Your ref:
Our ref: 21/01176/F
Please ask for: Mrs Lesley Raby
Direct dial: 01553 616818
Direct fax: 01553 616652
E-mail: borough.planning@west-norfolk.gov.uk

Details: **Self contained 1 bedroom annexe at 7 Malvern Close South Wootton King's Lynn Norfolk PE30 3UJ**

I have received a planning application as detailed above but cannot process it until I receive some more information:

DRAWN BY DB	CHECKED BY SR	DATE 29.03.2021
SCALE (@ A1) As indicated	PROJECT NUMBER 17249	DRAWING NUMBER 17249-02
DRAWING NUMBER 17249-02		REV 4

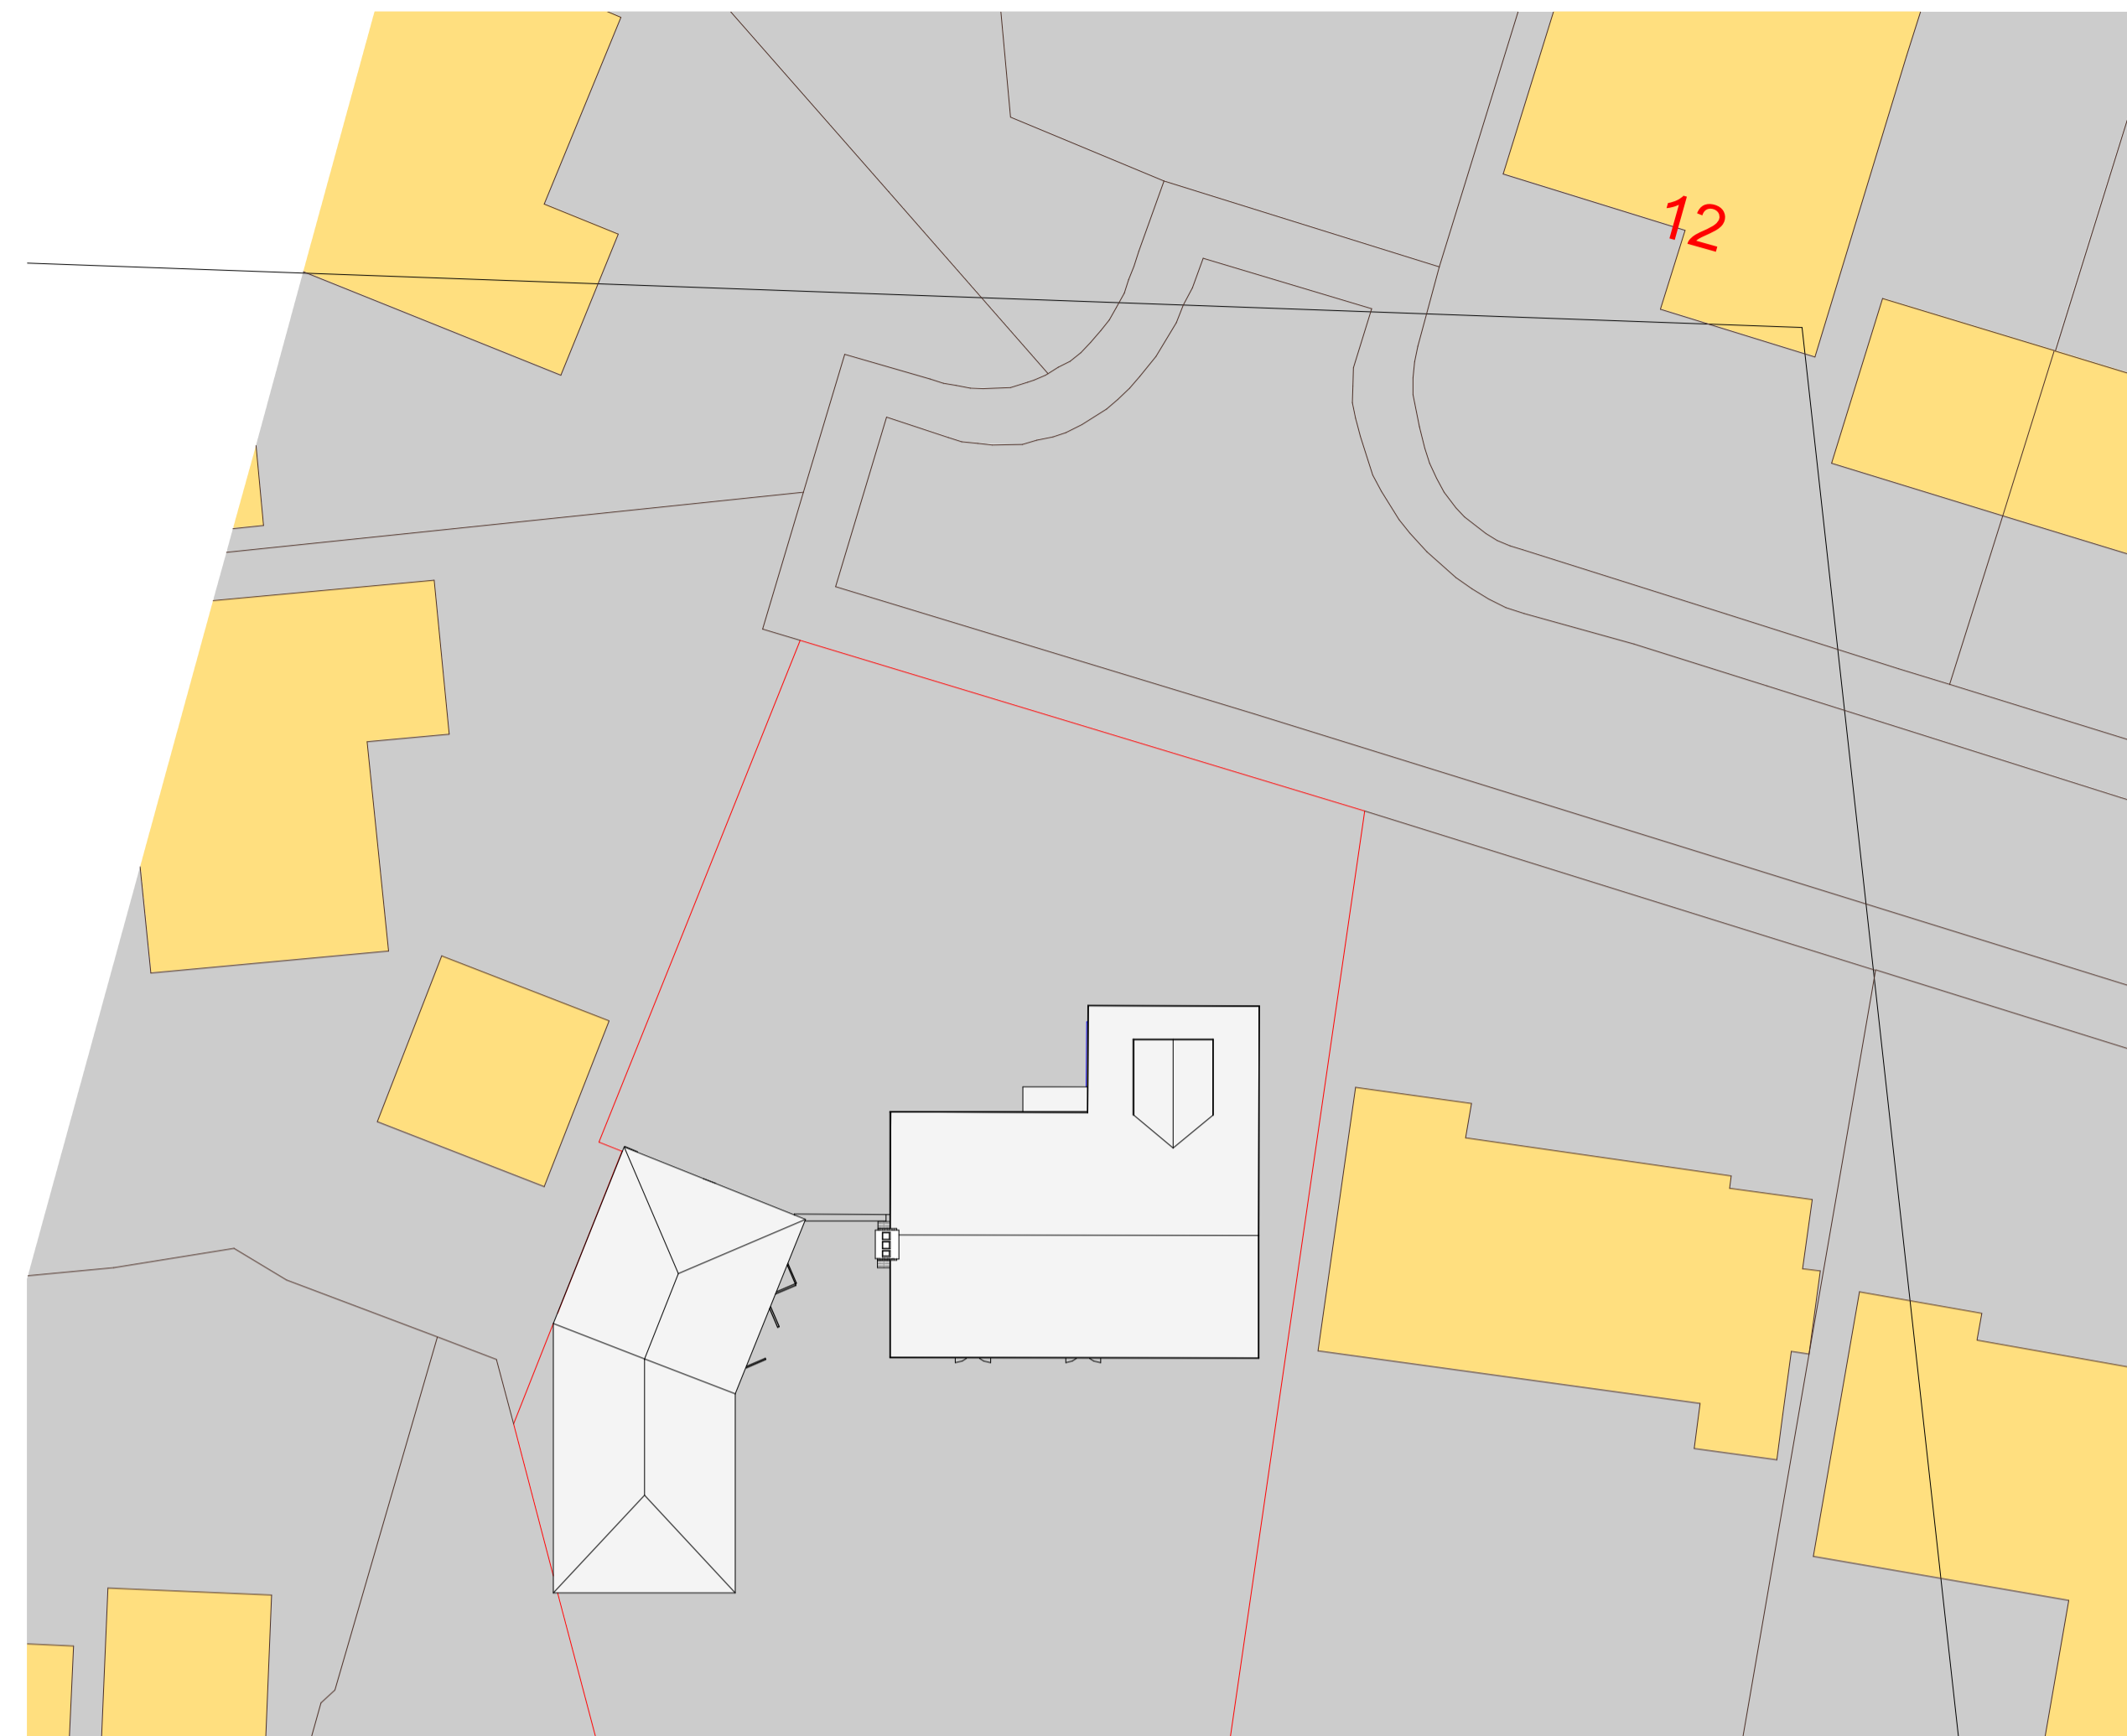
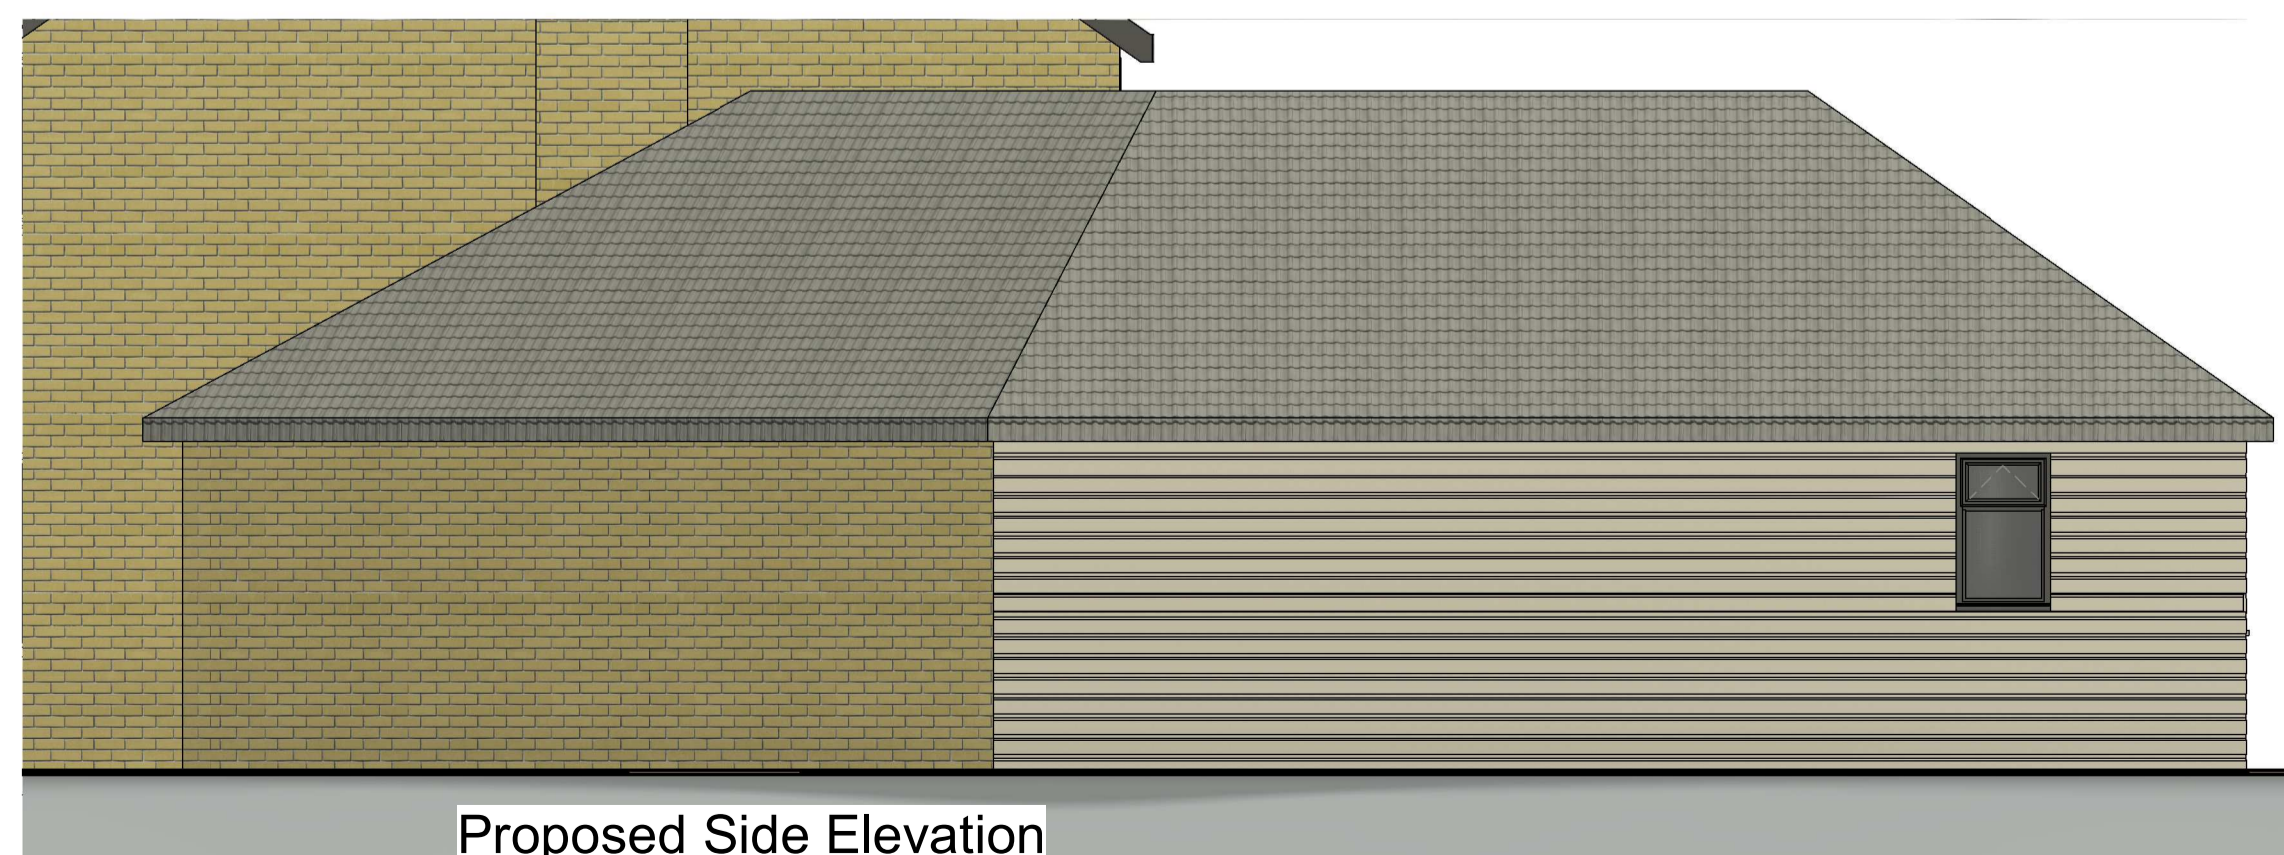
2. Confirm that the finished floor levels will match the existing floor level and that the site levels will remain unchanged.
